**Consultation Response from KC,
Lead Local Flood Authority**

2024/93026 land at, Manor Street, Newsome, Huddersfield, HD4 6NW

Discharge of details reserved by conditions 3 (materials), 5-9 (site contamination), 11 (external lighting), 12 (cycle parking), 13 (bin store), 14 (ecological design strategy), 15 (landscaping) and 16 (drainage) of previous permission 2022/90655 for erection of 10 student residential units with associated landscaping

Condition 16 - Drainage Details

20no. 1.0m x 0.5m x 0.39m Aquacell storage crates arranged in 4m x 2.5m grid and 0.4m deep to provide 4m³ of attenuation.

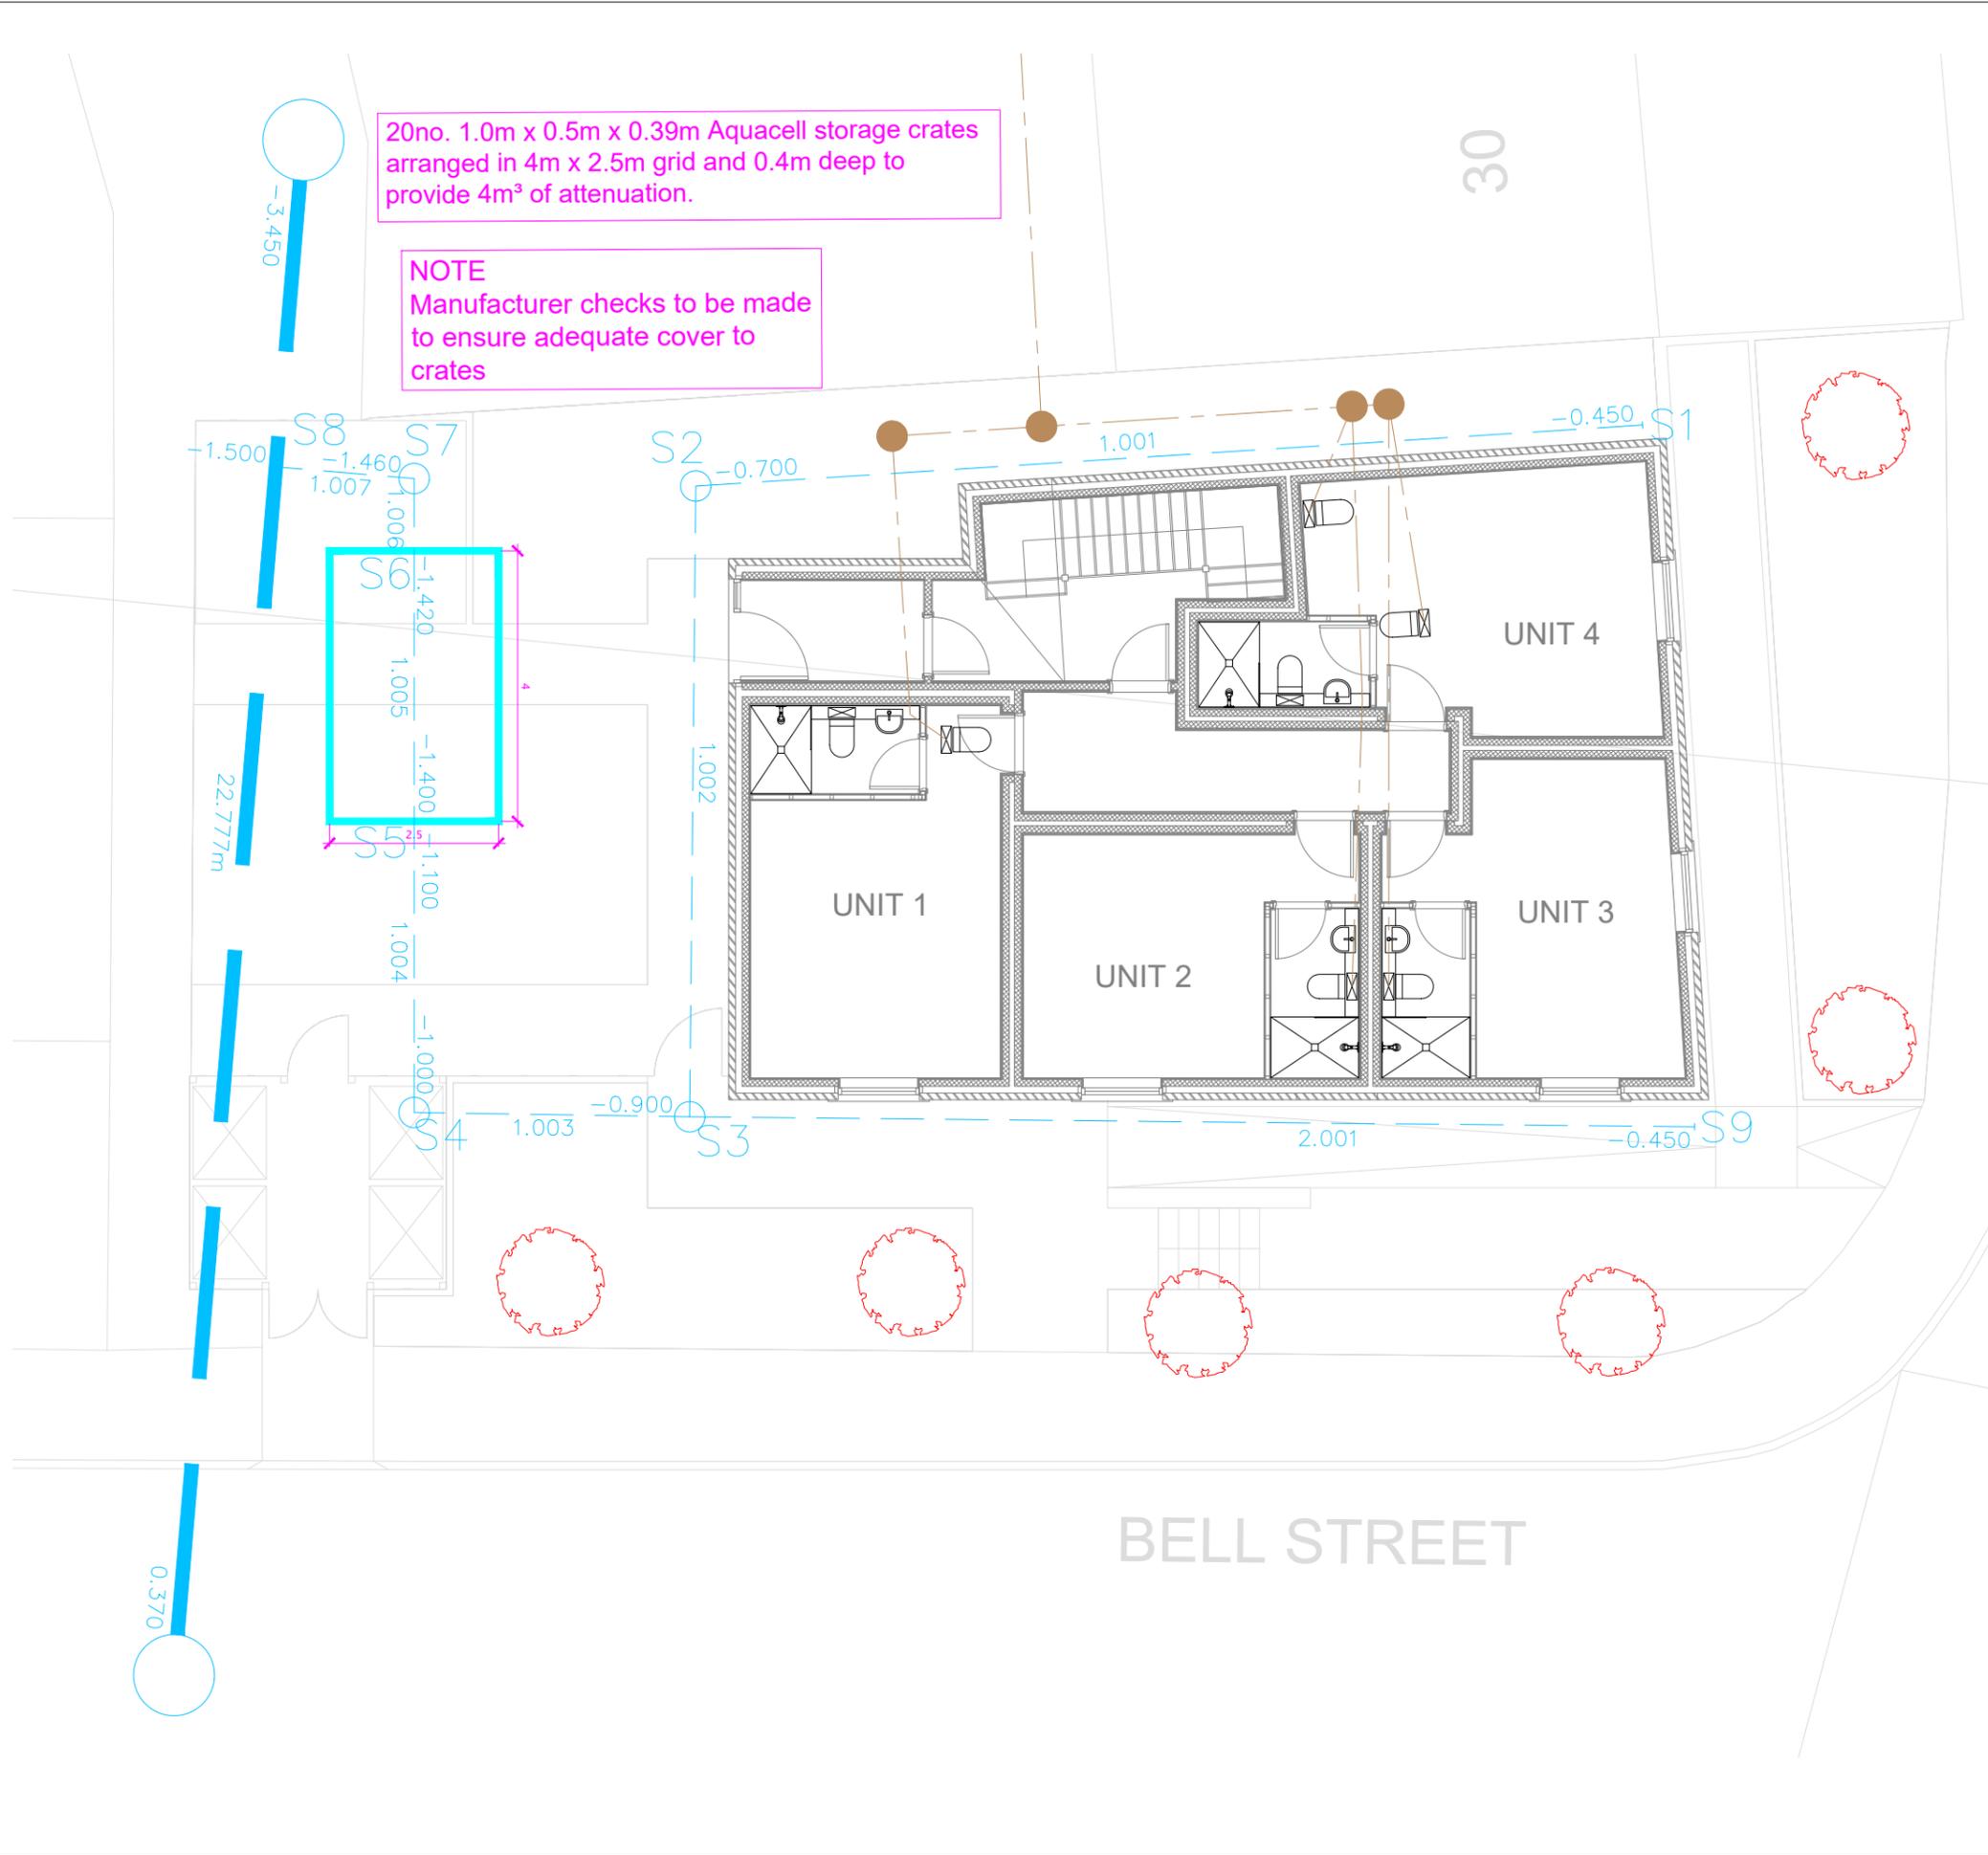
Having reviewed our original comments on application ref 2022/90655 and the condition set, it appears that Kirklees Flood Management & Drainage concluded an attenuation tank would not be necessary due to the size of the building.

Although attenuation is welcomed if feasible, we hold concerns about the proximity the culvert and a connection to it that should close to soffit level. The details suggest an invert level connection which is not feasible.

We do NOT recommend that this condition is discharged at this moment in time.
